From: Admin <admin@artconsultants.uk>
Sent: 09 September 2022 10:38
To: Zara Raza; satpalbajaj@hotmail.com
Subject: Re: 47989/APP/2022/1486 Outbuilding proposed at 68 Ashford Avenue Hayea

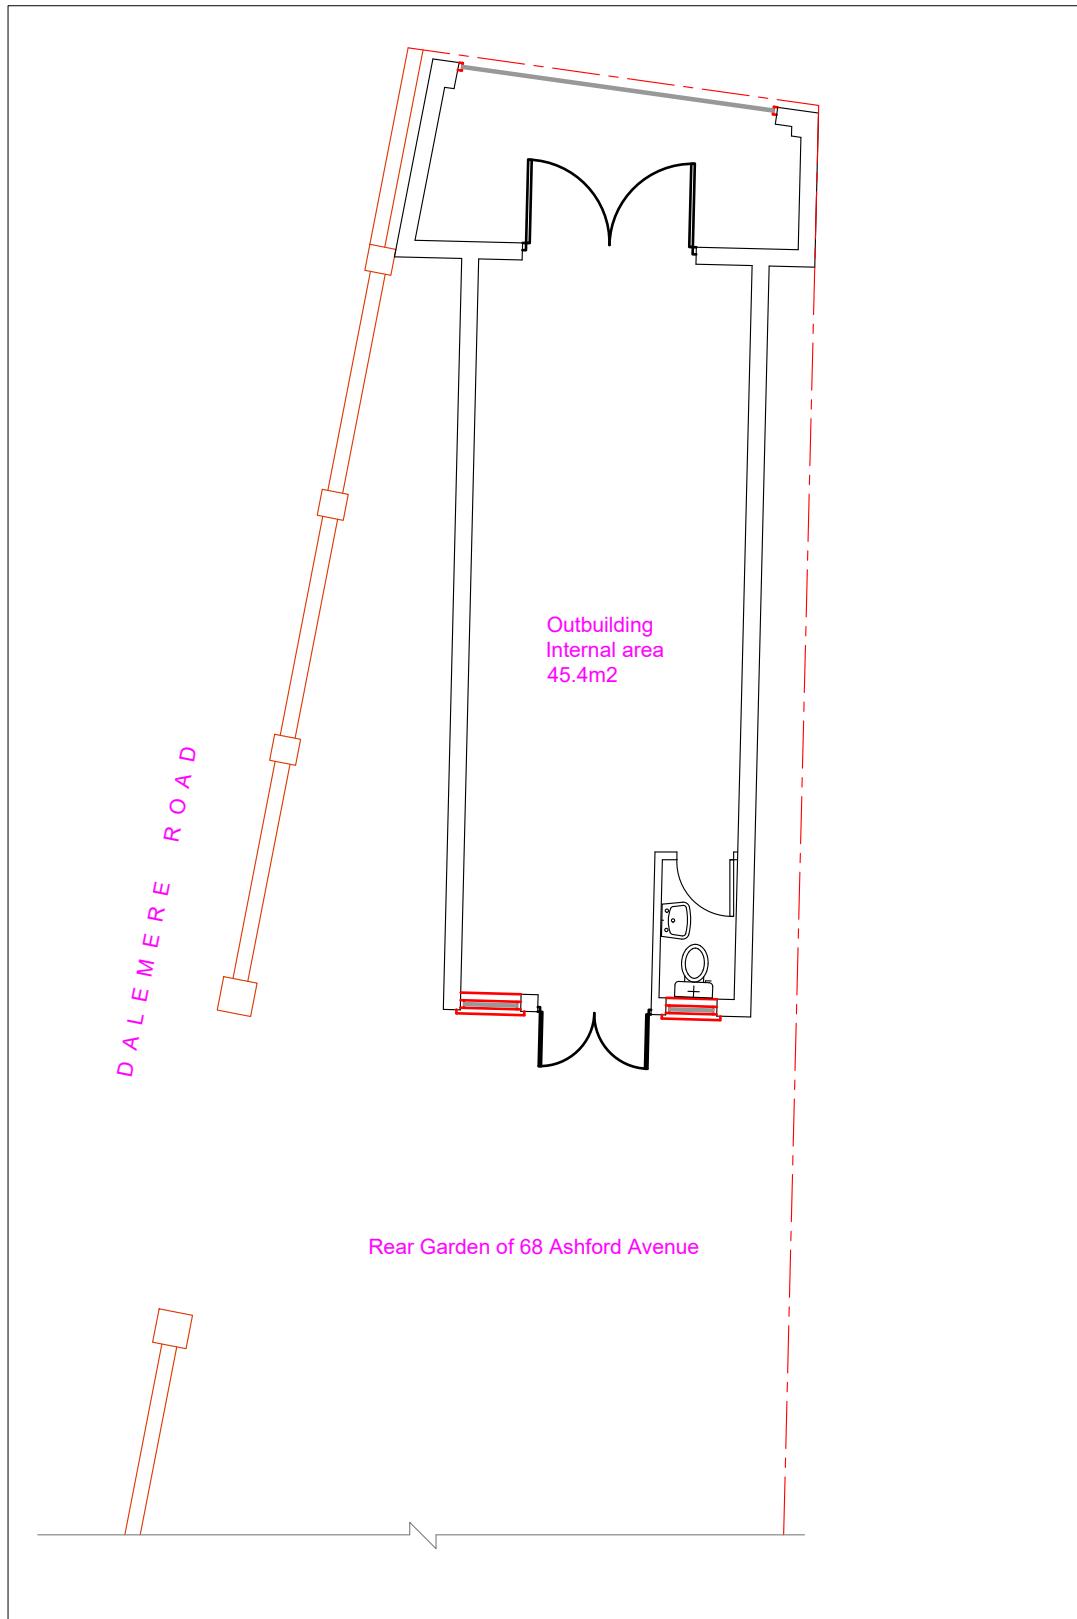
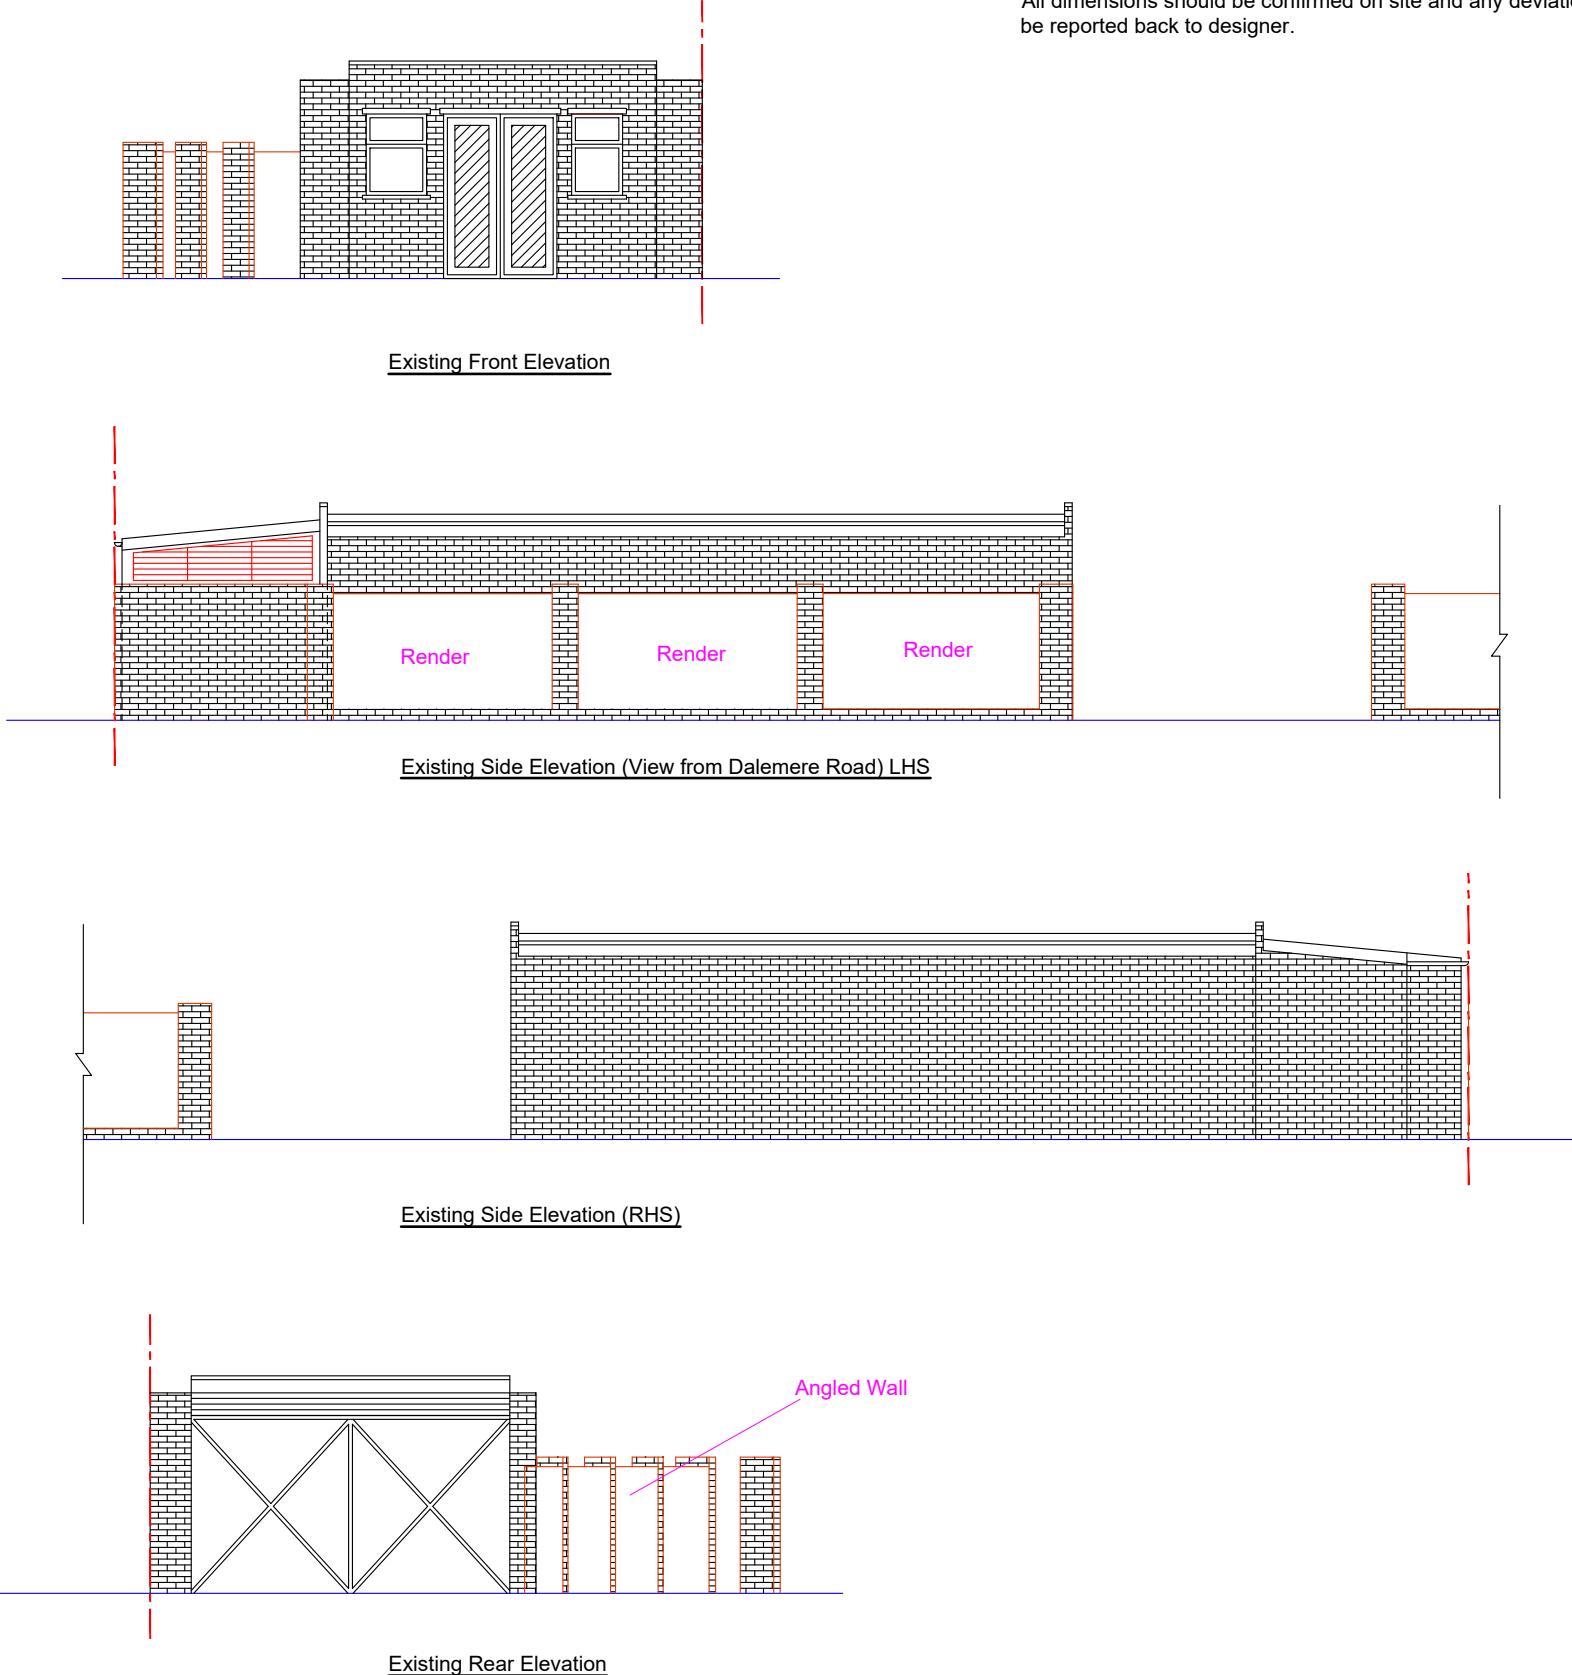
Kindly note the dimensions implied on existing drawings are right. I am sending you a screenshot of our survey notes.

Kindly note the existing outbuilding and rear structure are 12.6m deep and proposed outbuilding will be 12.2m deep so infact we are readucing the effection depth.

You would appreciate existing outbuiling along the boundry with nieghbour is approx 2.7m high and proposed eaves height is 2.35 thereby improve the outlook along the boundry.

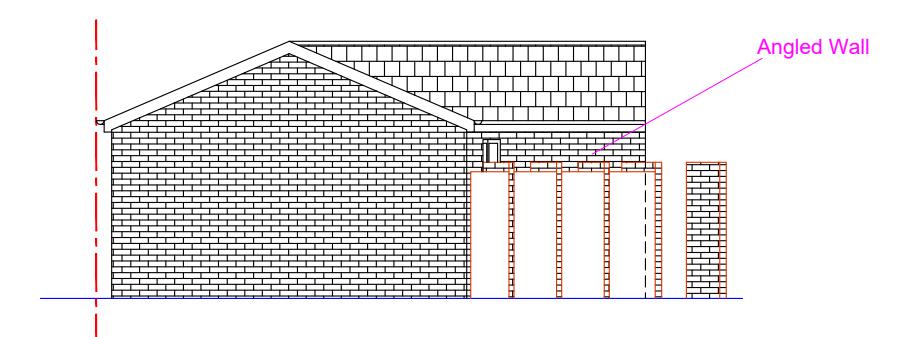
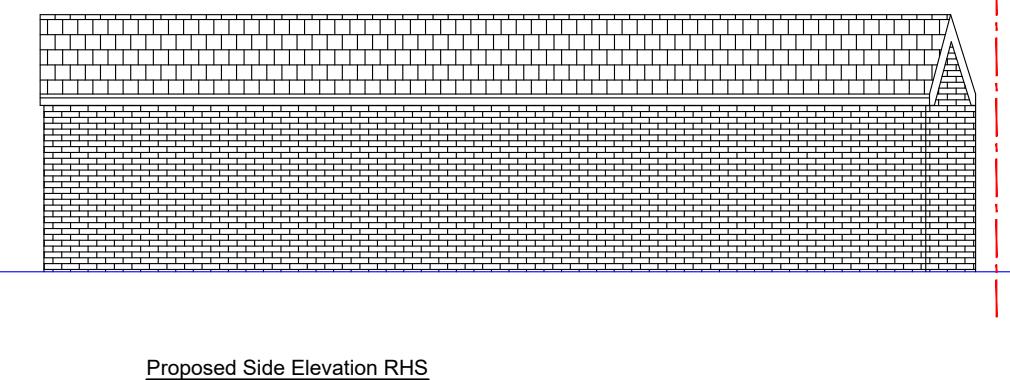
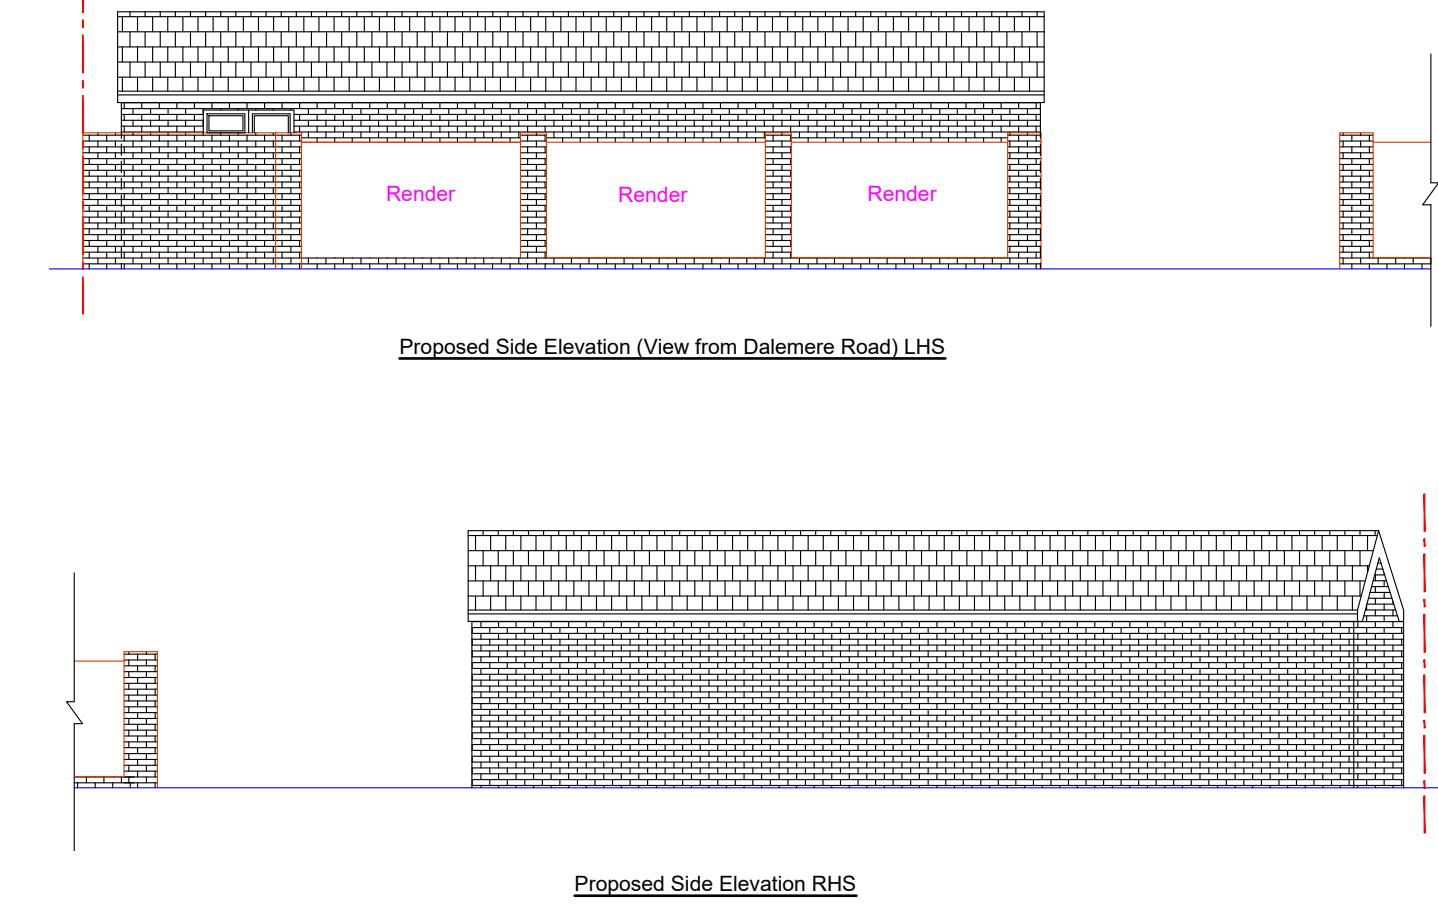
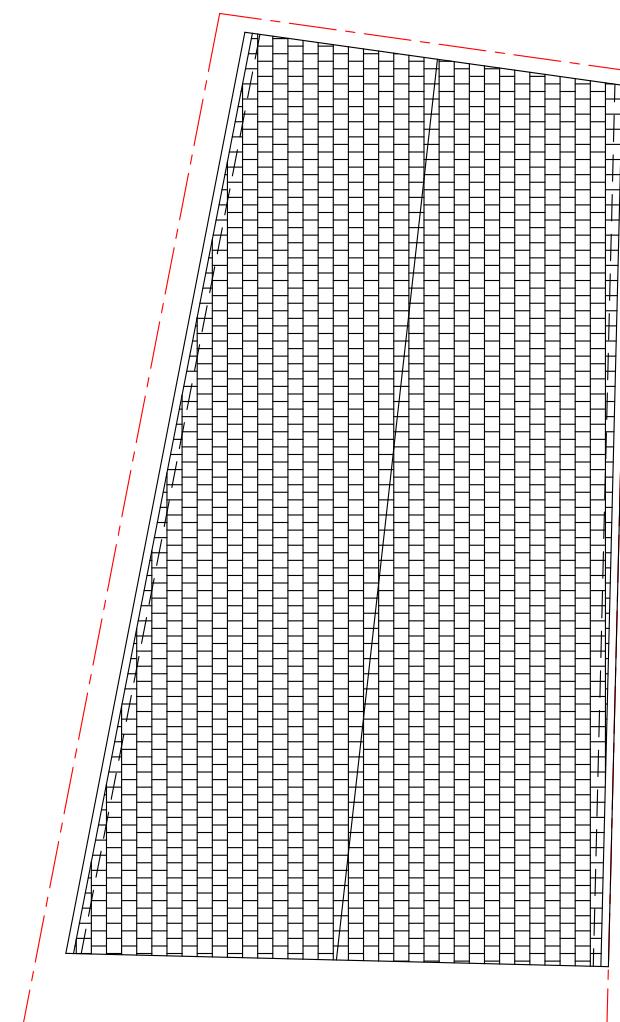
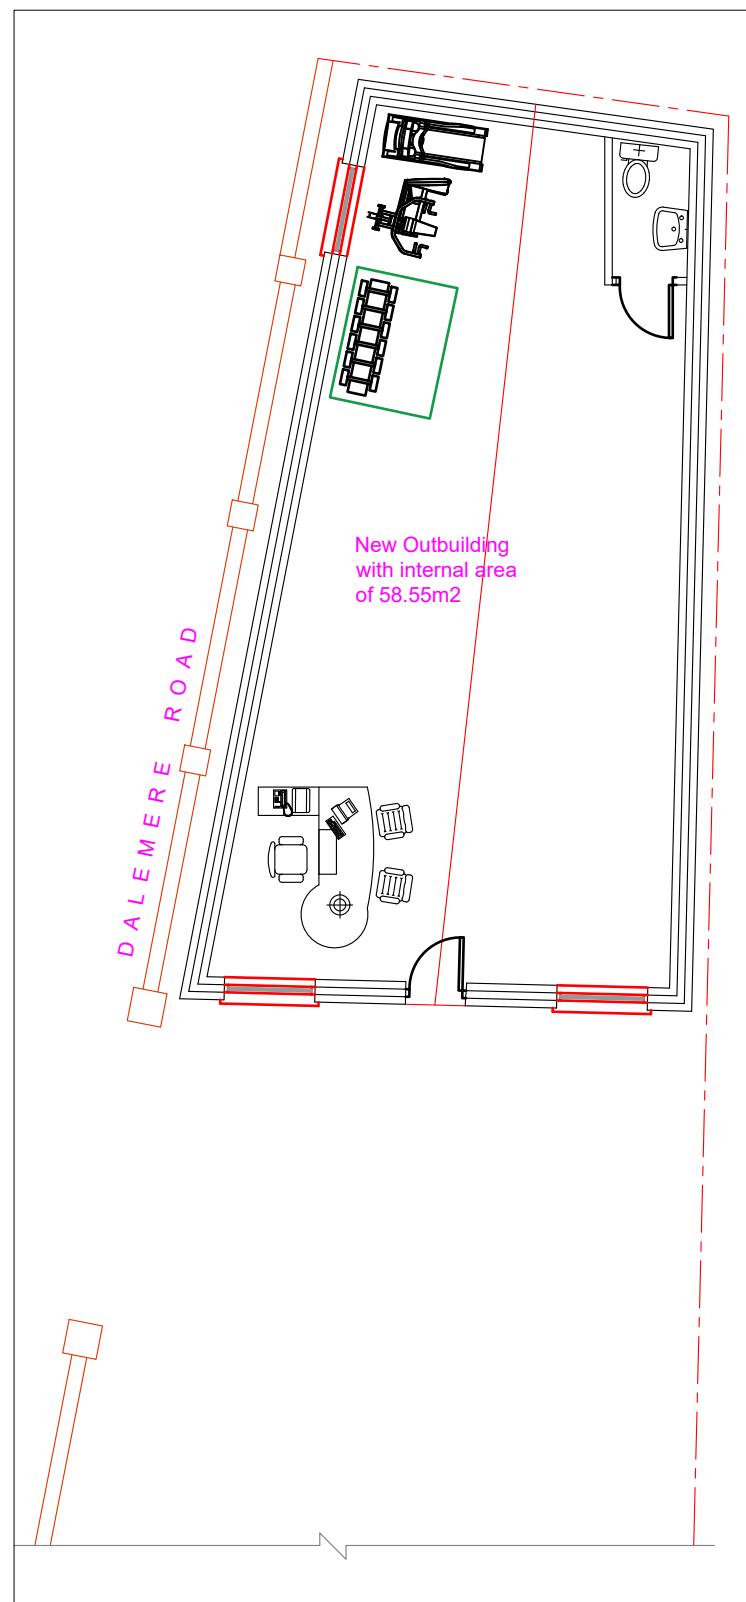
a) **height:** proposed eaves height is very modest 2.35 with ridge height 3.4m, If it helps we do have an opportunity to reduce the eaves height to 2.2 with ridge height of 3.2M. #

If you think reducing the height further by 200mm will enable you to support the application, I can get my client consent and get the plans amended asap, alternatively I suggest we meet on site to eliminate any confusion.
